Subject: **R-2246 C Response to DWQ ON HOLD Letter**; DWQ Project No.  
030845

On July 9, 2003 a permit application for TIP Project no. R-2246 C (DWQ Project no. 030845) was submitted to DWQ. This letter addresses each item in your July 11, 2003, "on hold" letter regarding the widening of the Concord-Kannapolis Westside Bypass. A copy is attached for your convenience.

PROJECT: 8.2661601 (R-2246C)  
CONCORD-KANNAPOLIS  
WESTSIDE BYP EXT FROM  
SR 1451 TO SR 1555

**SITE 1
 PLAN VIEW**

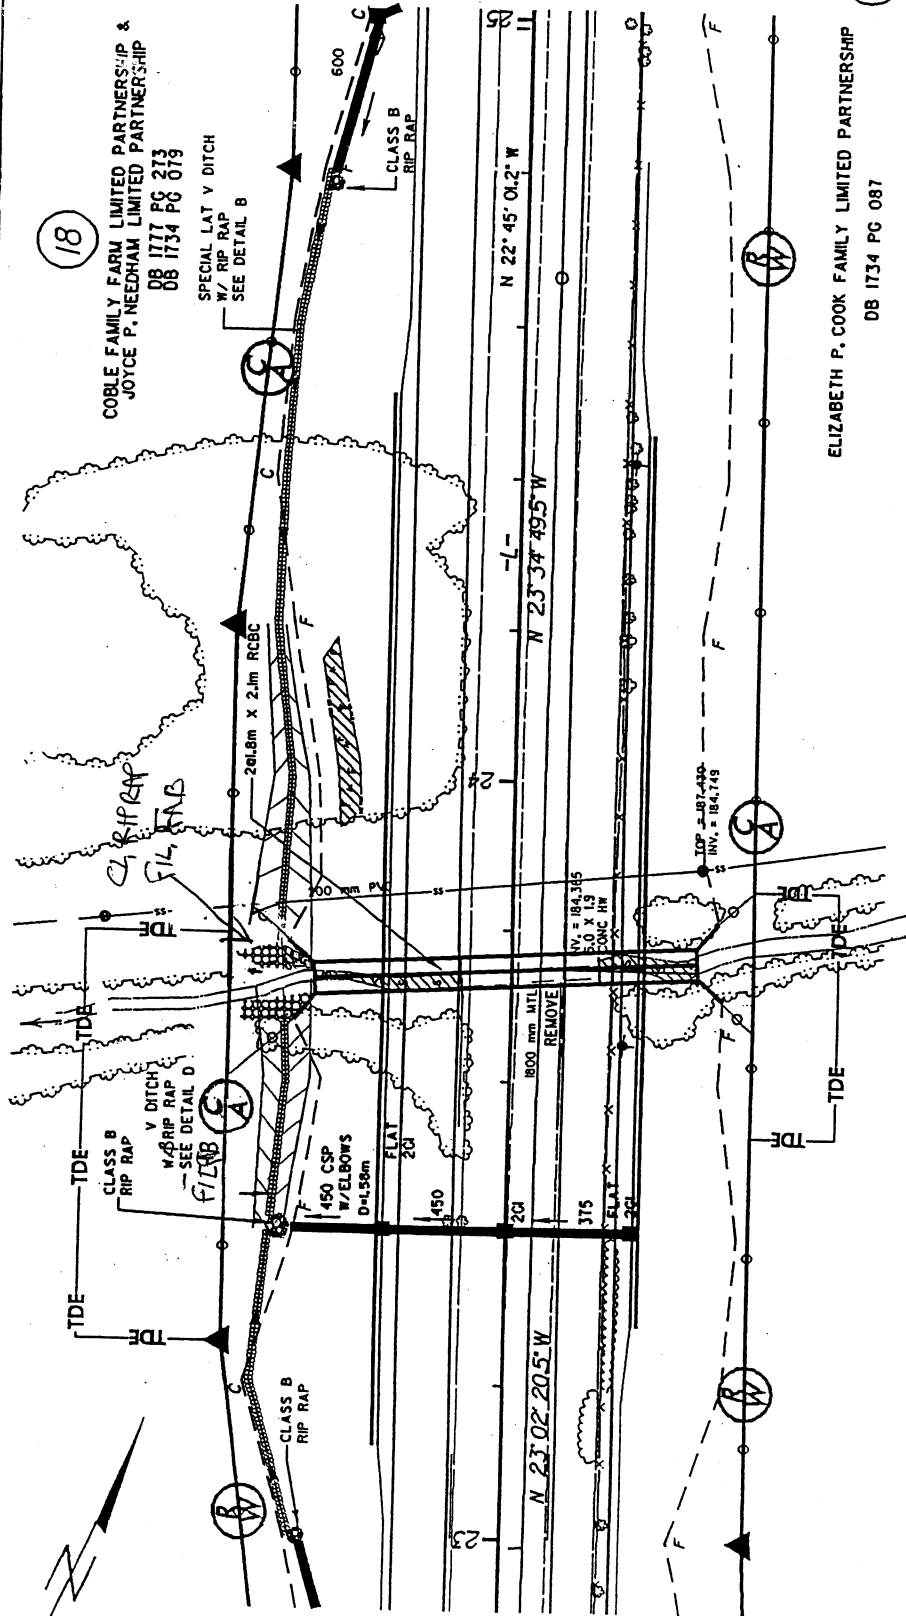
3. NCDOT Hydraulic Design Unit has re-designed the two crossings of the unnamed tributaries to Coddle Creek, a 303(d) listed stream, to provide pre-treatment of the storm water runoff before entering the streams. The new design provides wider grass swales and the elimination of riprap in order to use permanent soil reinforcing matting (PSRM). The discharge from the pipe exceeds the allowable quantity of water to use preformed scour holes, and the topography is too steep to use detention basins or level spreaders. Wider grass swales and the use of PSRM instead of riprap will perform the same function as preformed scour holes and detention basins. This design will not exacerbate the cause (urban runoff/storm sewers) of the 303(d) listing for Coddle Creek.

The revised permit drawings and the revised half size plans show details "N", "M", and "L". These details correspond to "D", "J", and "B" on the original drawings. Details "N", "M", and "L" have PSRM in the bottom of the lateral base ditches. Details "D", "J", and "B" have class B riprap in the bottom of the lateral base ditches.
